December 14, 2023

Re: Dunkin Drive-Through  
3520 Menaul Boulevard NE  
HT#H16D122

Kenig, Lindgren, O'Hara, Aboona, Inc. (KLOA, Inc.) has received the City of Albuquerque's comments in the September 8, 2023 letter regarding the above-referenced development. Below are our responses to the comments.

C100

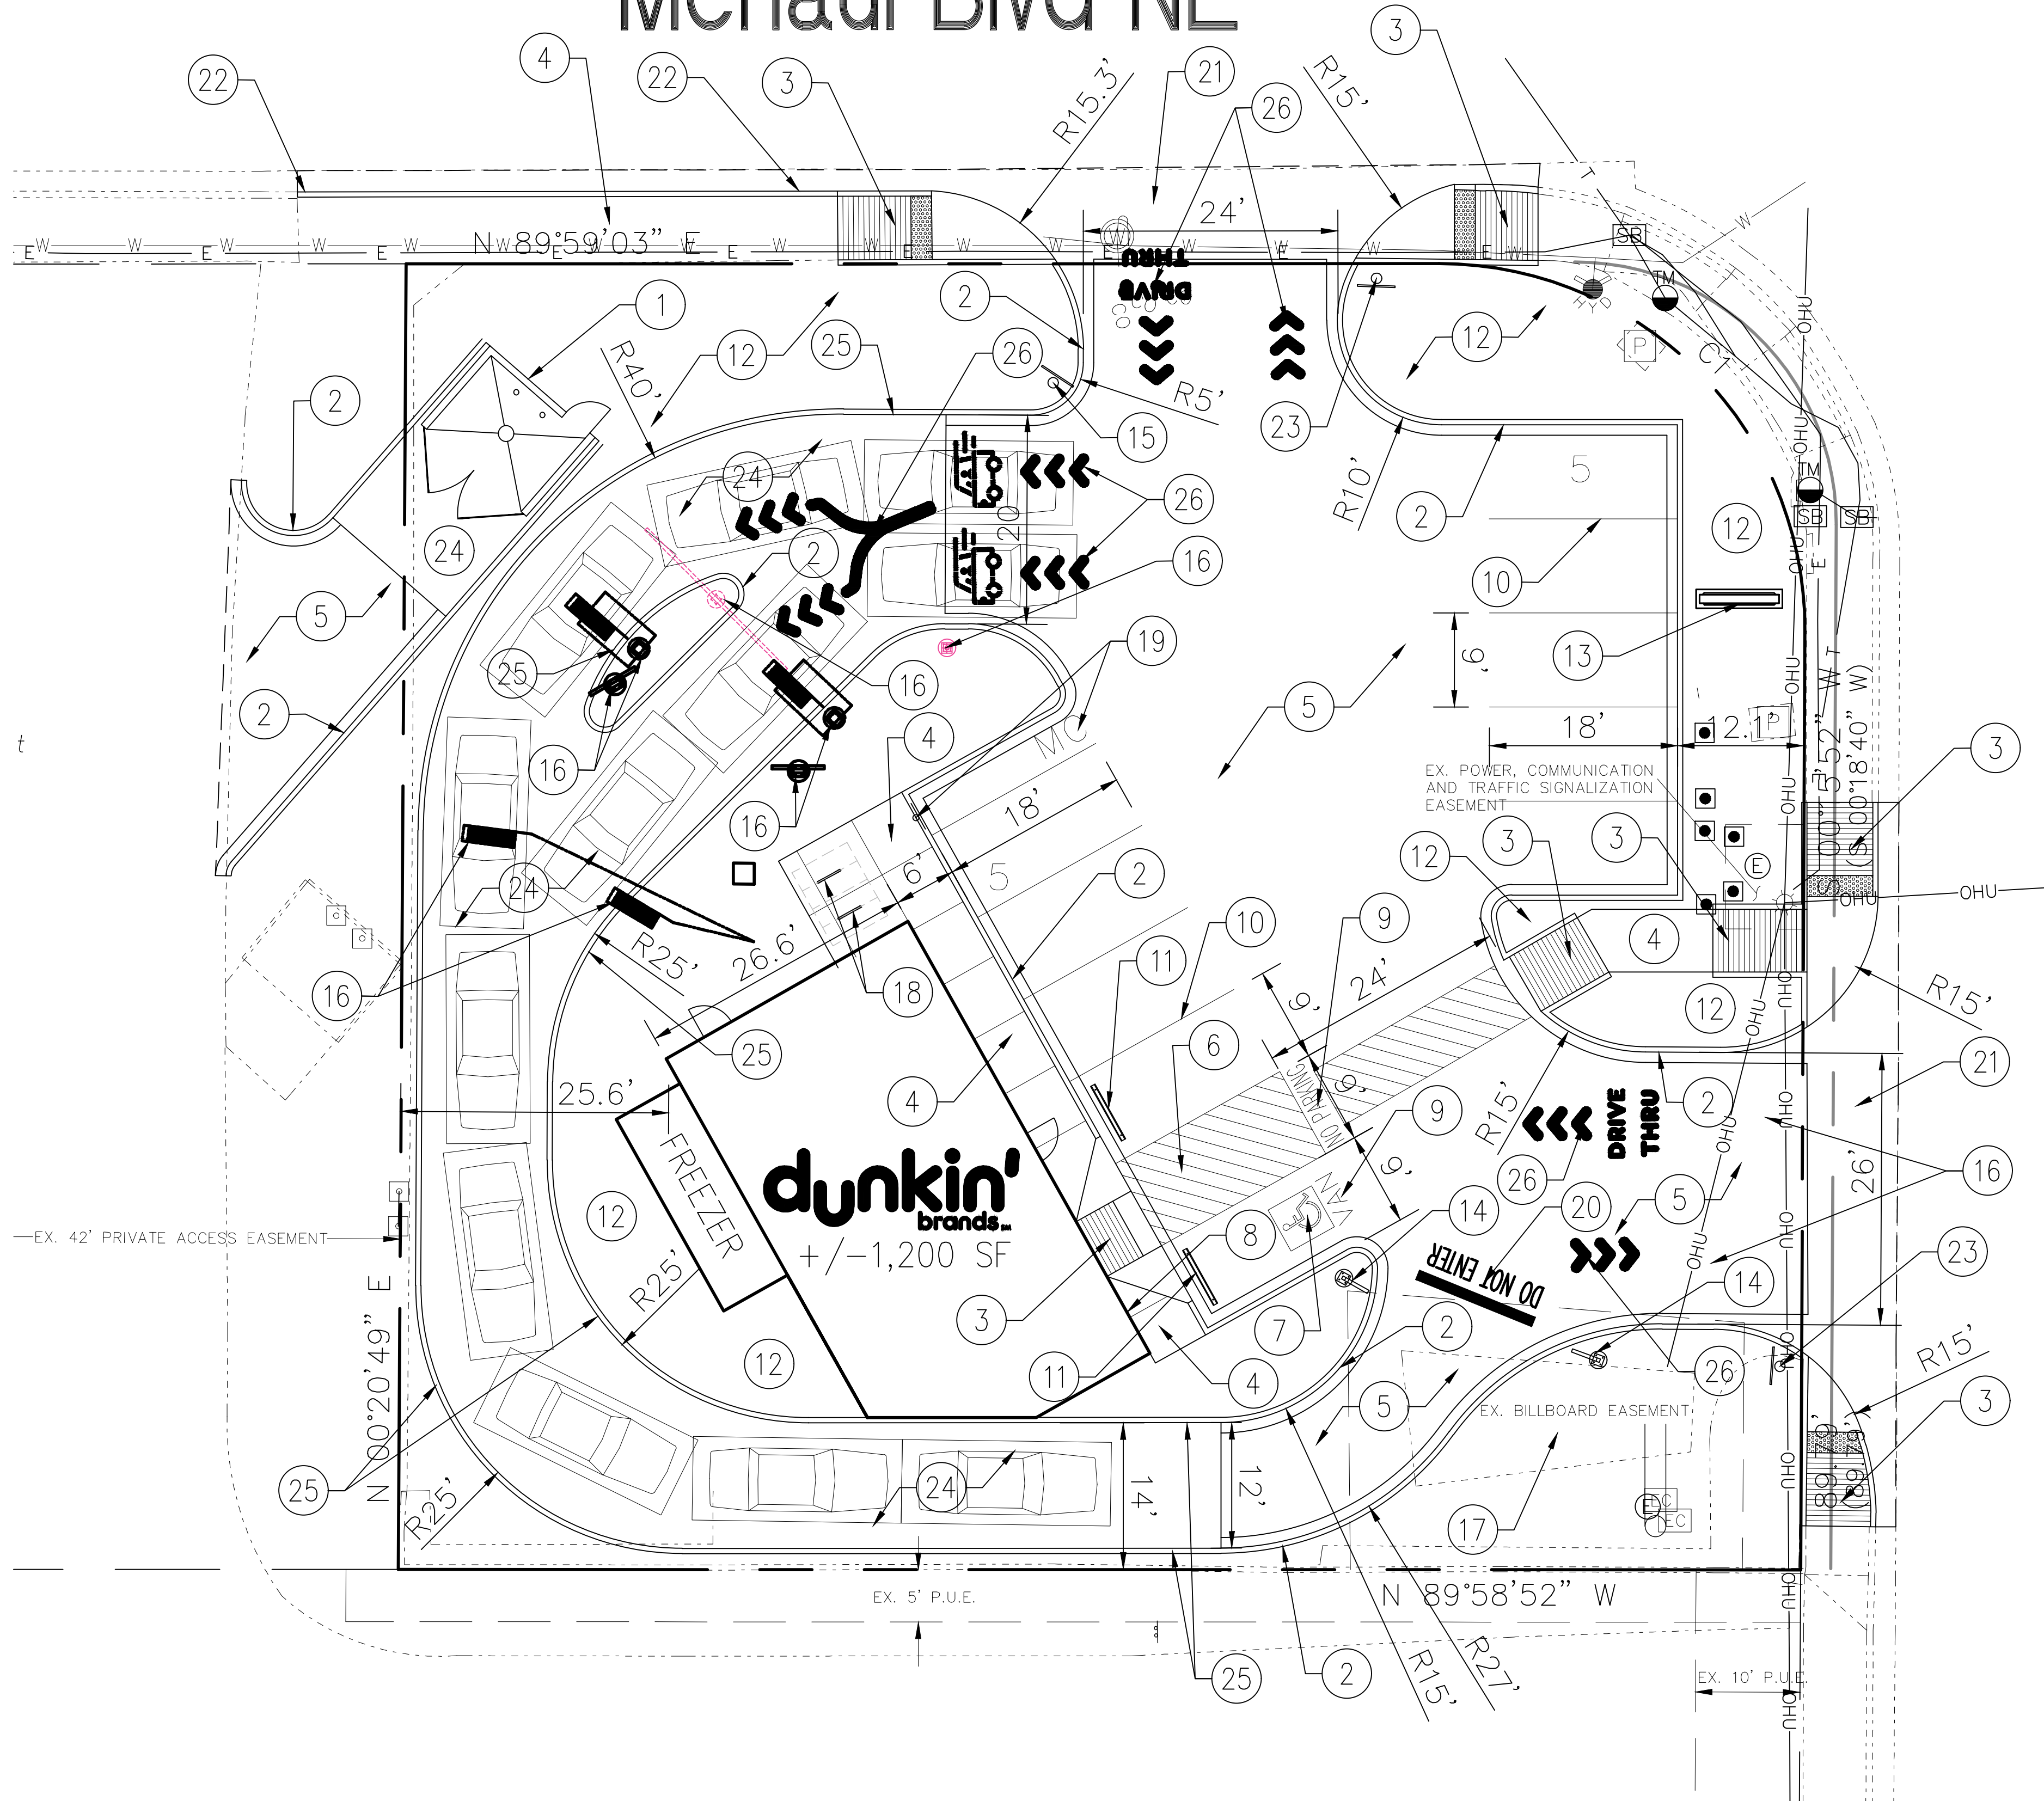
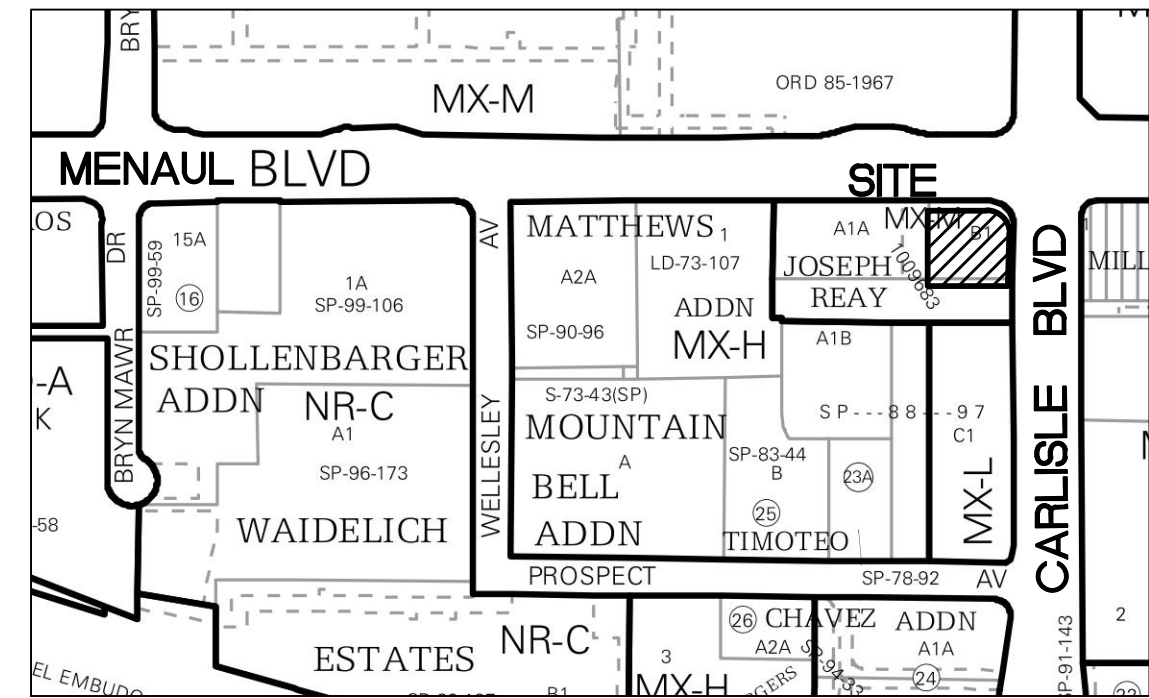
The access driveway on Menaul is too close to the intersection. Refer to CITY DPM TABLE 7.4.45 Minimum Distance Between Commercial Site Access and Intersection. When an access is located on a Principal Arterial approaching an Arterial the minimum distance for a commercial access from the intersection is a minimum 300 feet. Provide a discussion on the available frontage along Menaul for access and the potential of sharing access with the properties to the west of your proposed development. The City would prefer a shared access on Menaul farther towards the west if the property owners are willing to share access and the driveway operations are shown to be acceptable.

- Note that the site access shall comply with CITY DPM TABLE 7.4.45 Minimum Distance Between Commercial Site Access and Intersection. The proposed site access driveway on Menaul Blvd is not in compliance being to close on the approach to Carlisle.

**Response: The orientation of the building, drive-through, and access has been designed to ensure that maximum on-site stacking is provided for drive-through vehicles so that vehicle queues do not spill onto Menaul Boulevard NE. This orientation also prohibits the ability to provide cross access to the west. Text indicating these items have been incorporated in to the revised traffic study.**

**Response: As previously indicated, the location of the proposed access drive was designed to provide maximum on-site drive-through stacking. This indication has been added to Page 29.**
